Re: **Wyoming Mall-Starbucks**
Project #: PR-2021-005461
Application #: SI-2023-01170

Please find the following responses addressing comments received in a letter dated July 18, 2023. In an effort to address your comments concisely and simplify your review of these development plans, we have summarized your comments and our responses below. Your comment is listed first, followed by the response in Bold.

SHEET NUMBER
L1.0

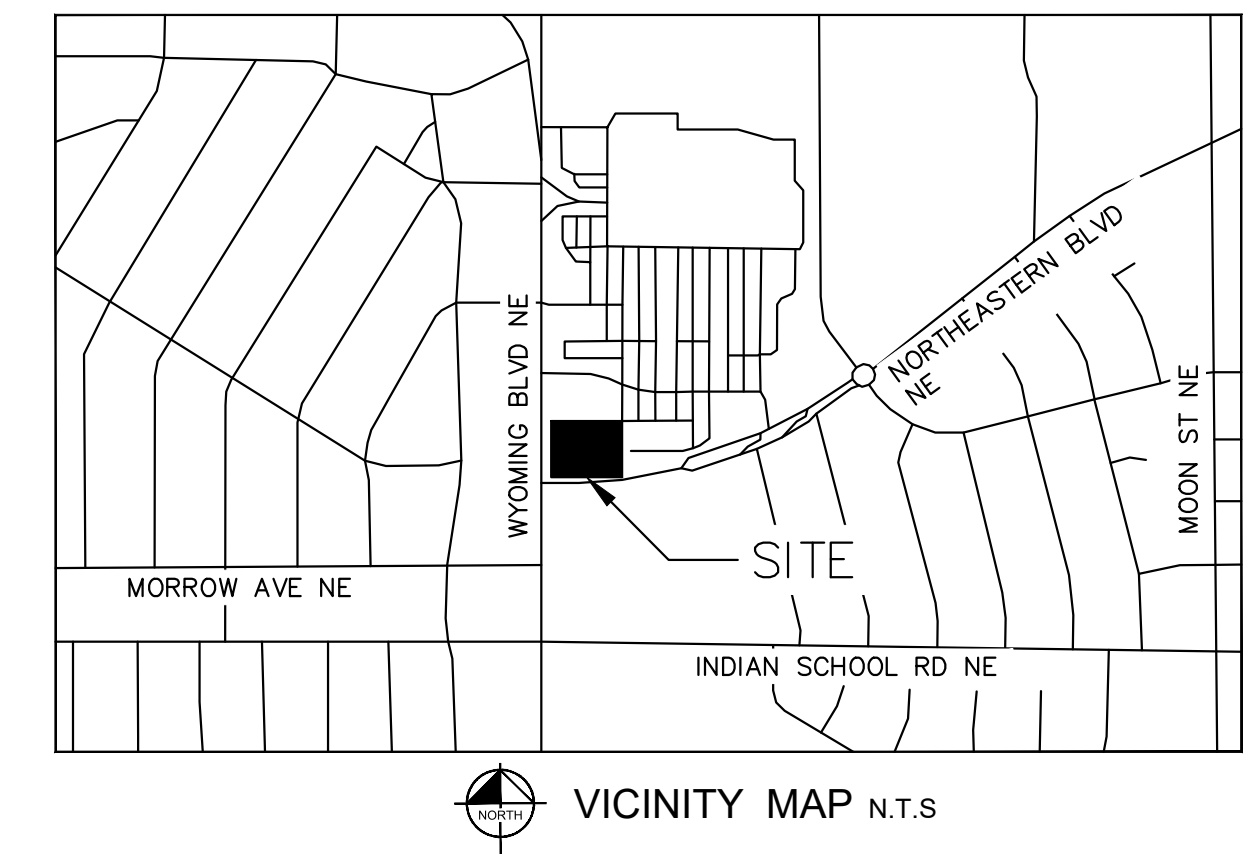
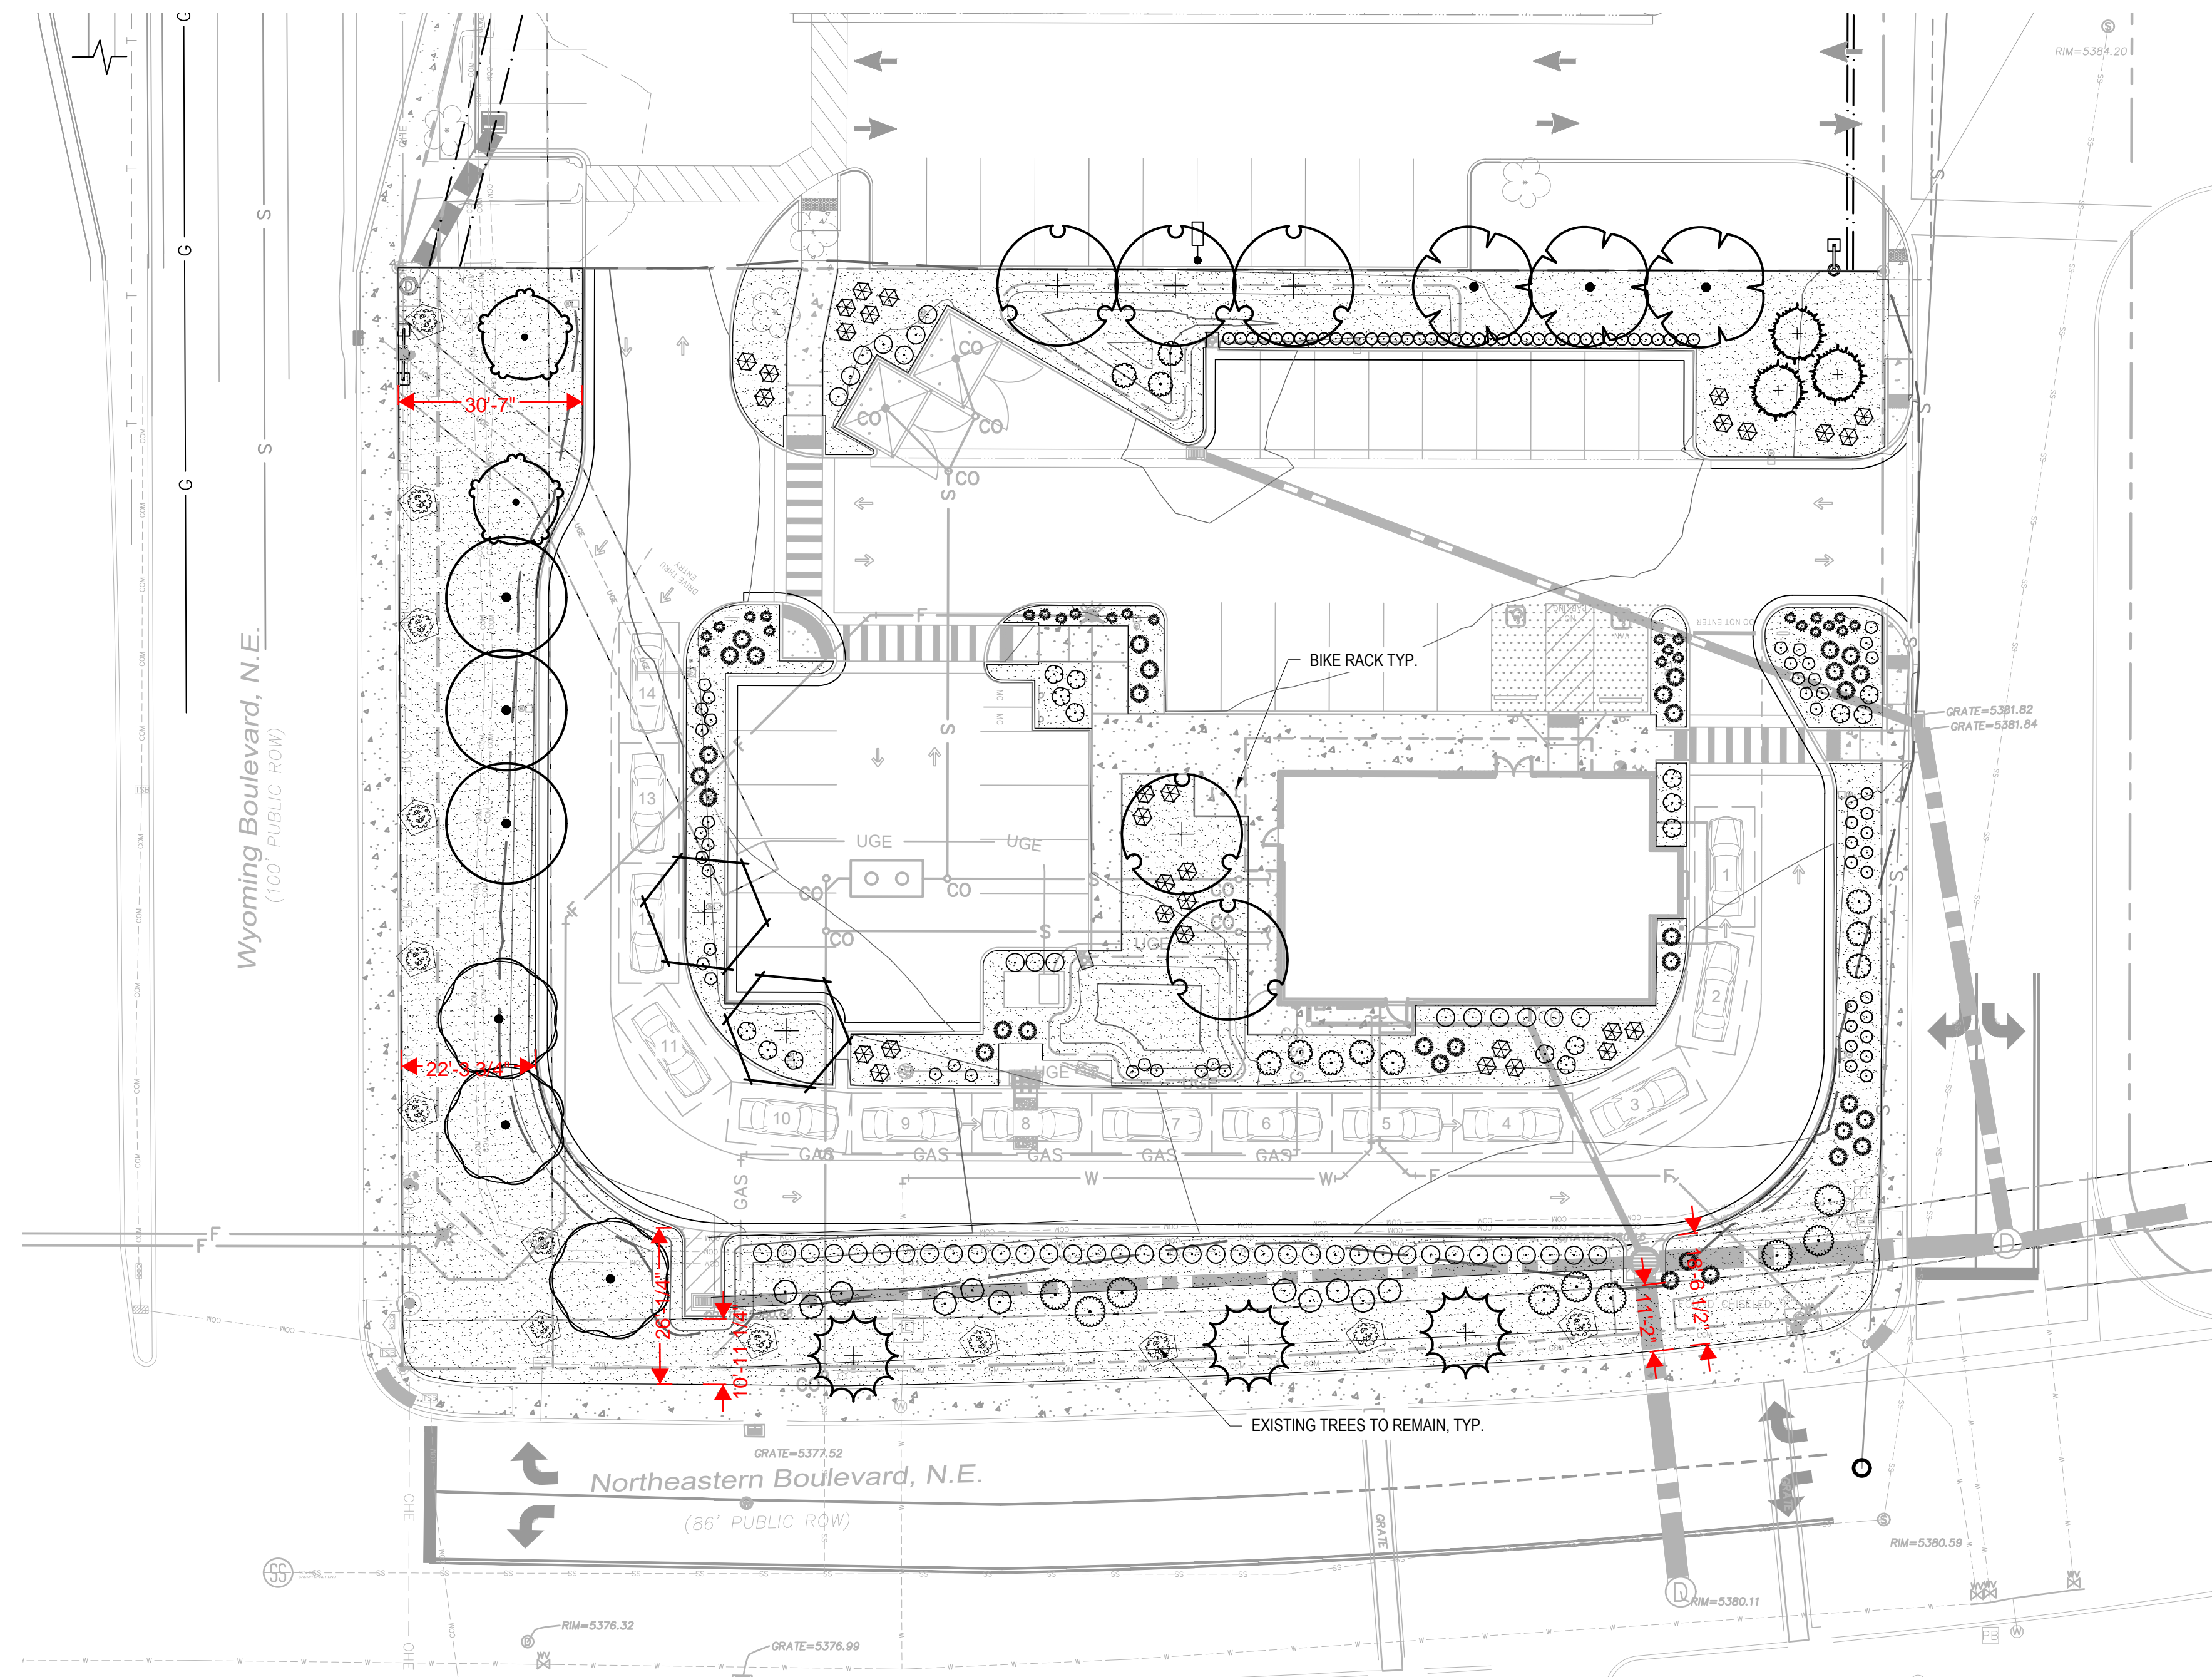
Comment 3: Please identify/clarify the maintenance responsibility for any landscaping/buffering materials within an easement and/or ROW area.

Comment 7: As per IDO section 5-5(l)(2)(a), Drive-through lanes adjacent to public rights-of-way shall be screened by a landscape buffer area at least six feet wide containing a vegetative screen or wall...at least 3 but not more than 4 feet tall. There are a number of bushes provided along Northeastern, but they show only 18-24 inches in height, and there are very few bushes along Wyoming, insufficient for a vegetative screen. Please confirm that the landscape plan provided will meet these requirements, and add notes to that effect on Landscape Plan L.1, accordingly.

Response 3: See sheet L1.0 for an updated note about maintenance responsibility.

Response 10: Additional species has been placed in the landscape buffer area. There is an existing 6' wall that will remain within the buffer area on Wyoming.
